Advice to the local planning authority

To LPA	Kirklees Council
LPA planning ref no	2026/70/90607/W
Our ref	26-0331
Site address	Crown House, 12, Southgate, Huddersfield, HD1 1DE
Proposal description	Variation of conditions 2 (plans), 3 (C(E)MP), 9 (external materials), 10 (BEMP) and removal of conditions 7 (bin store materials), 8 (bin store fire safety strategy) on previous permission 2022/93932 for change of use of Crown House to provide student-only living accommodation (sui generis) in the form of studios (198), with ancillary concierge and communal facilities including an open plan lounge, coffee bar and gym at ground floor, with laundry, car parking, cycle store, parcel store and plant rooms at basement level and associated works including the installation of new cladding and fenestration to the elevations with a new roof garden atop the building
Date on fire statement	NA
Date consultation received	23/03/2026
Date response sent	02/04/2026

Proposed side elevation
1 : 200

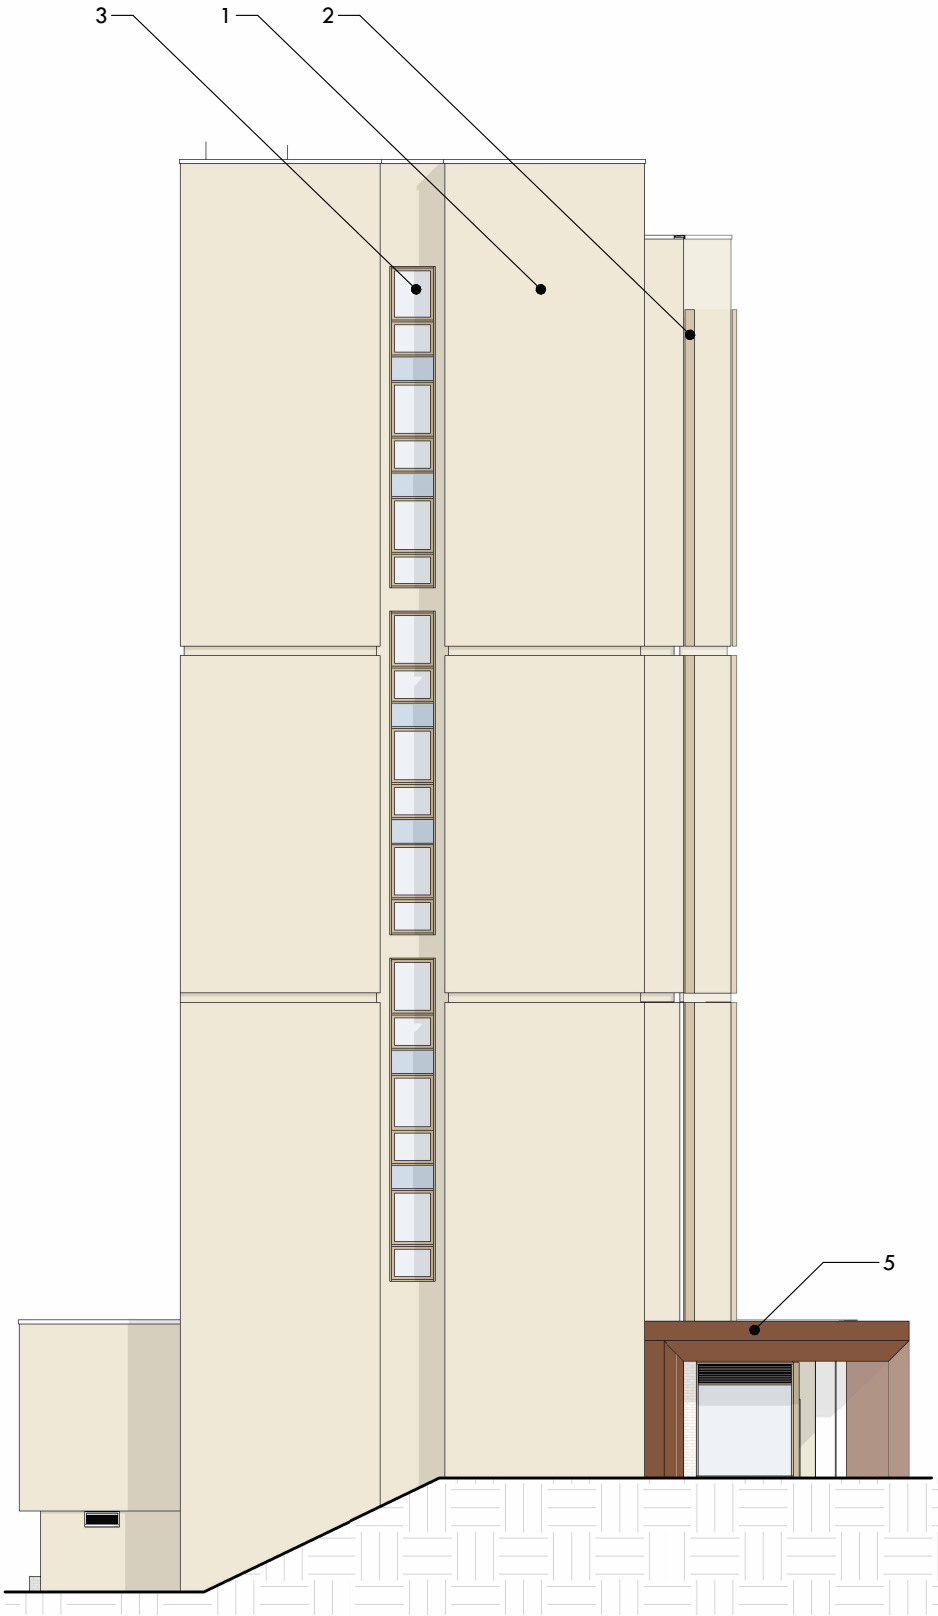
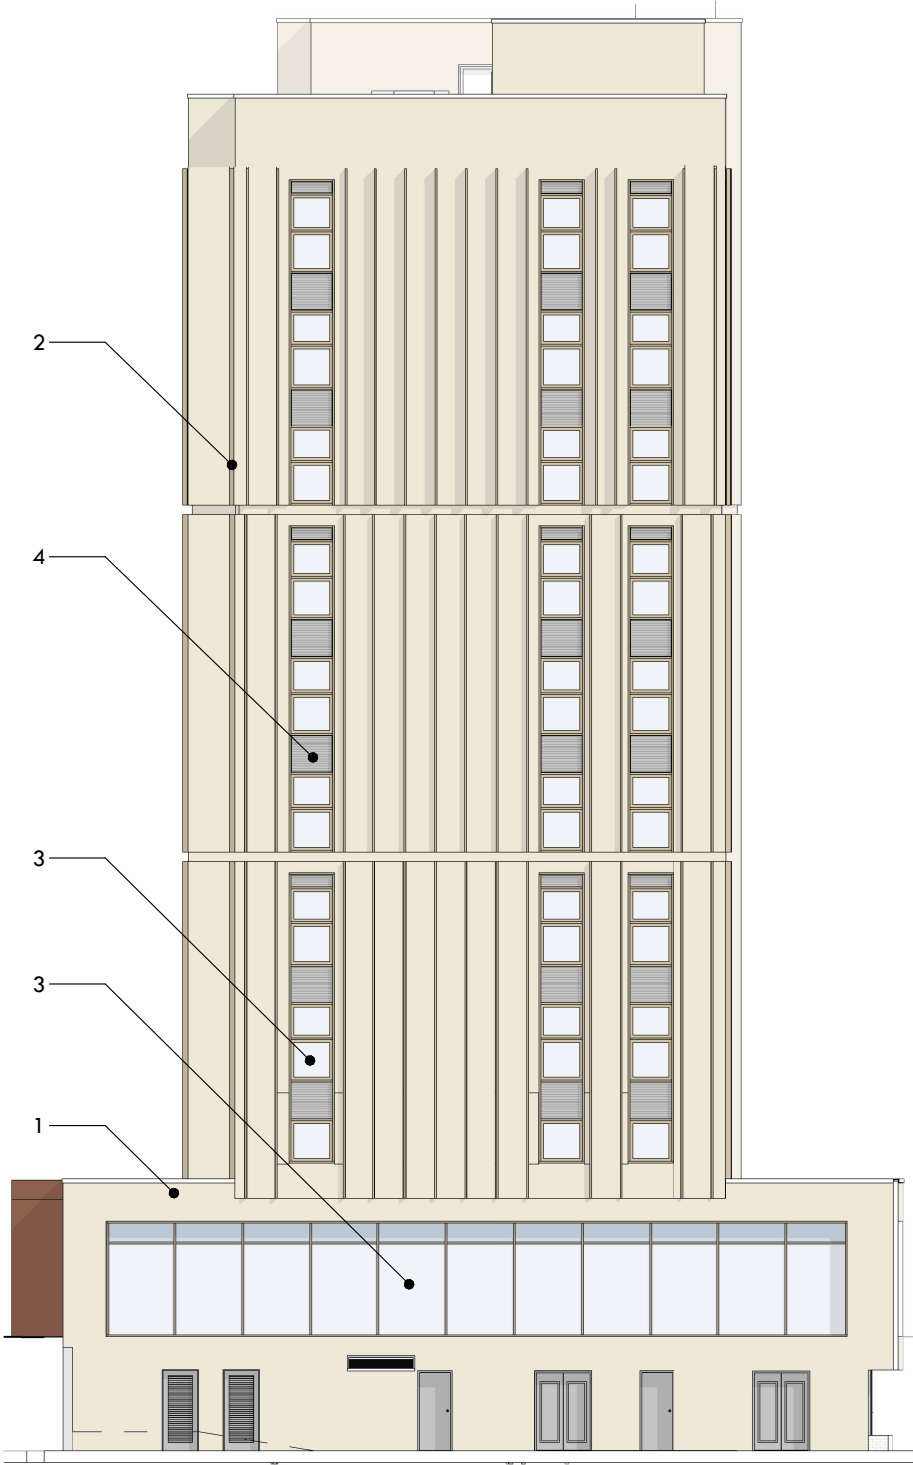
- 1.7 However, it is noted that the proposed elevation drawings reference a number of external wall materials, but do not state the reaction to fire classification of proposed materials.

- 1.8 The above 'content' headline is conditional on all materials which become part of an external wall having a minimum reaction to fire classification of Class A2-s1,d0. The LPA may wish to verify this with the applicant. The BSR should be reconsulted if this minimum fire classification is not proposed.
